Your Ref: OWPC23416
Our Ref: M/32/19/PL 10-04-2019
Please ask for:
Mrs A Gardner

New dwelling & separate garage replacing the proposed new house in the previous planning permission ref: M/7/16/PL - Amendment to M/153/18/PL

46 Sea Lane Middleton-On-Sea

**Elevation Materials
North**

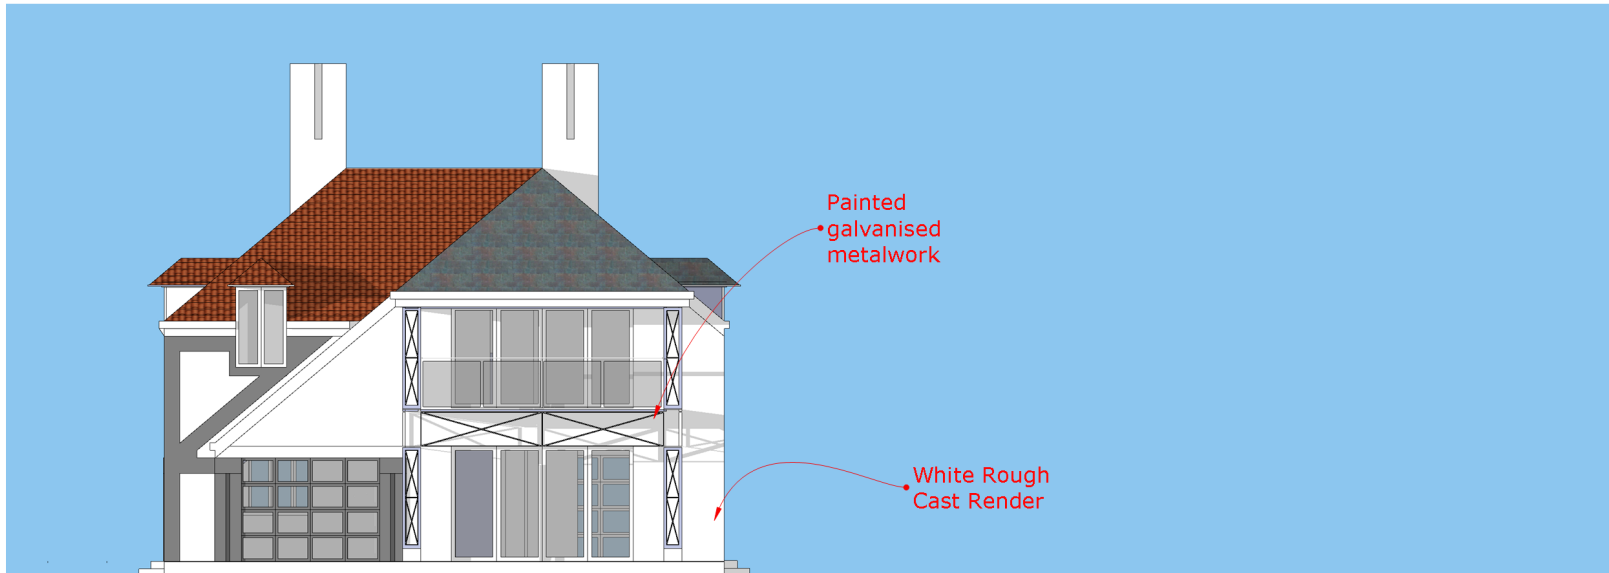
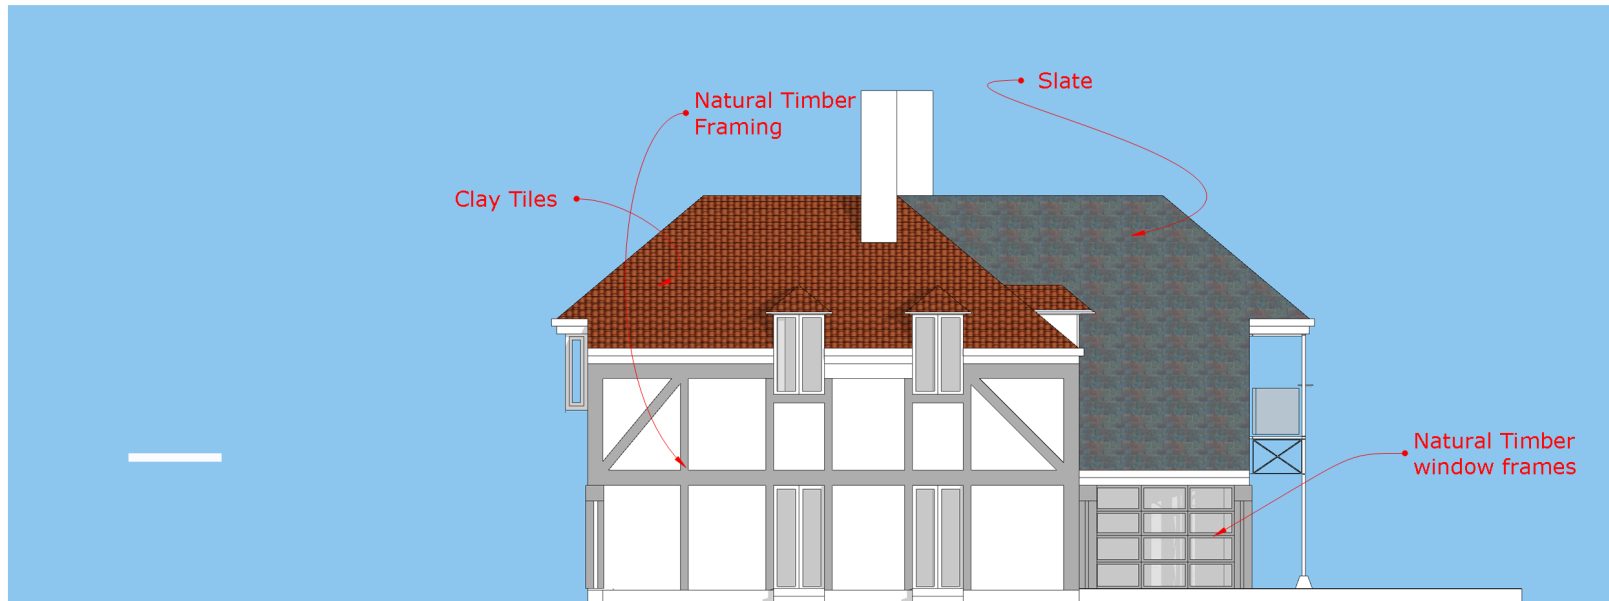
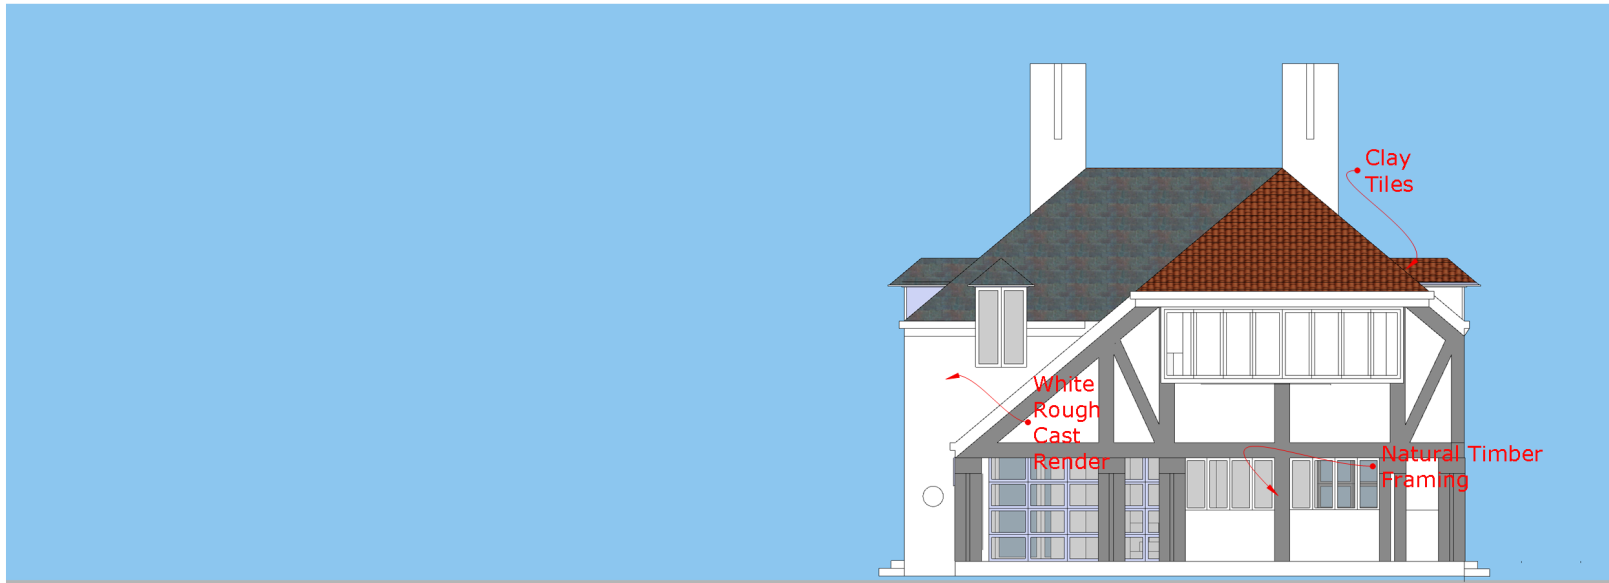
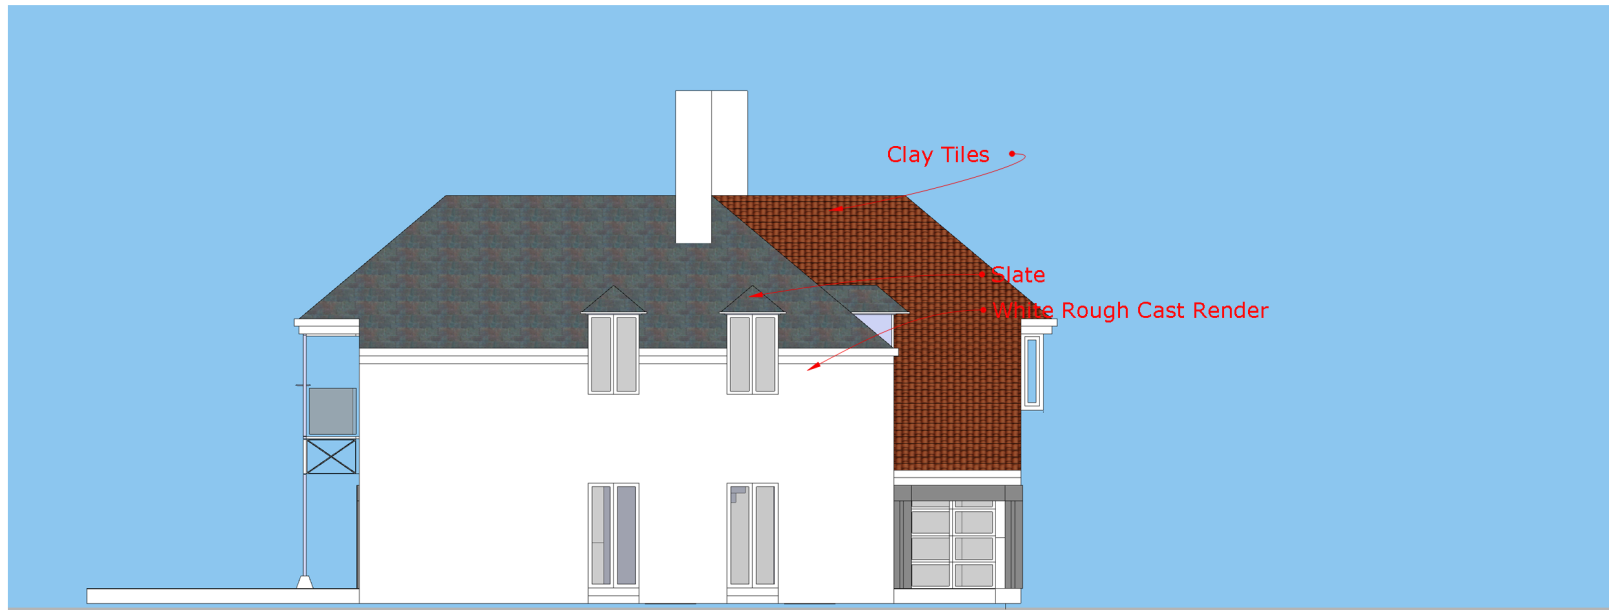
The proposed building is much too large for the location and size of the plot (over development). Please note that this proposal is larger than the previously approved application for the same plot. I do not believe that the proposal fits with the Middleton-on-Sea Village Design Statement (for example the tile/slate combination is out of character with the street scene).

North Elevation 1:100 @A3

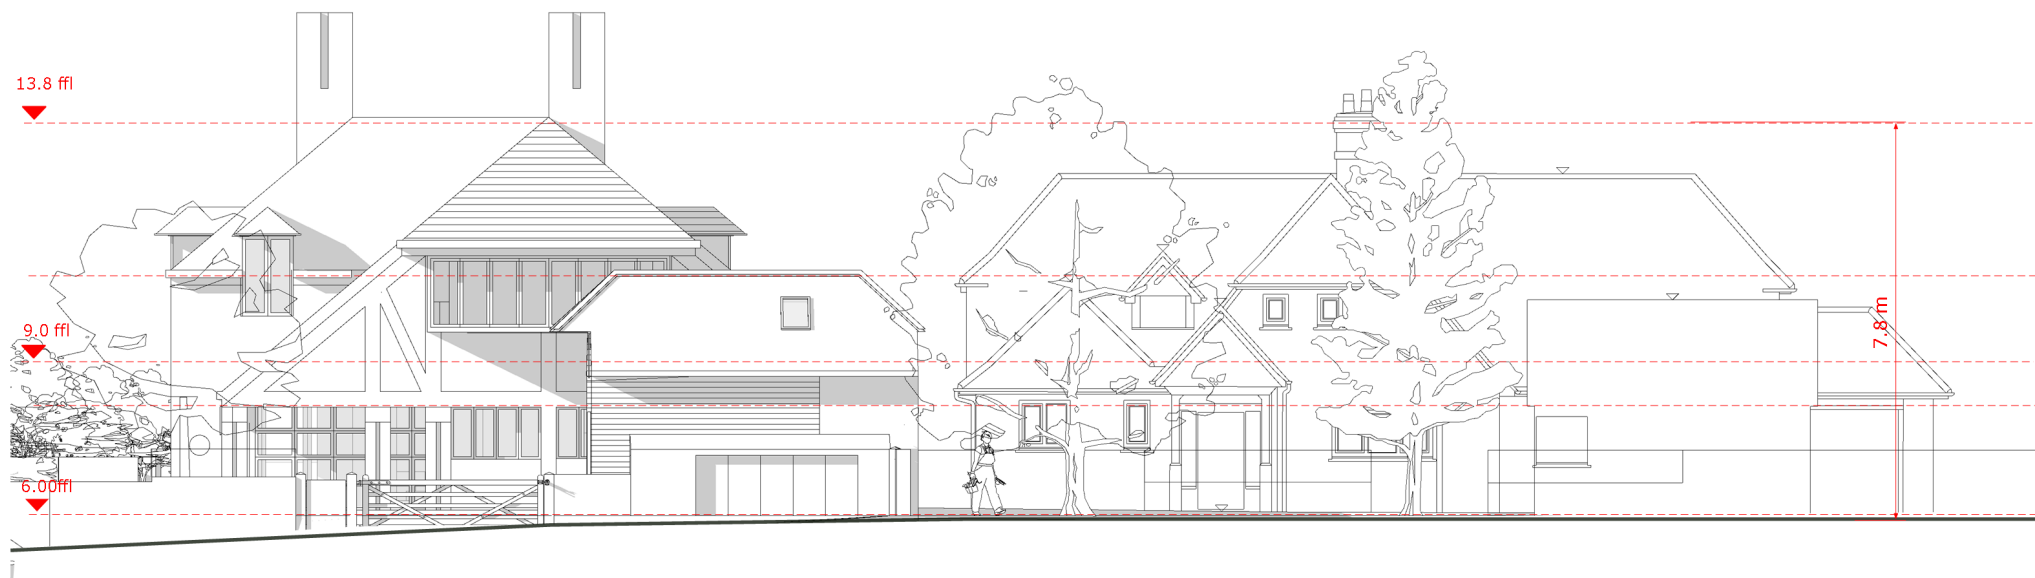
I am the immediate neighbor to the North. I am concerned that the proposed large first floor window on the North elevation is overlooking our garden (this is a new feature from the previously approved application).
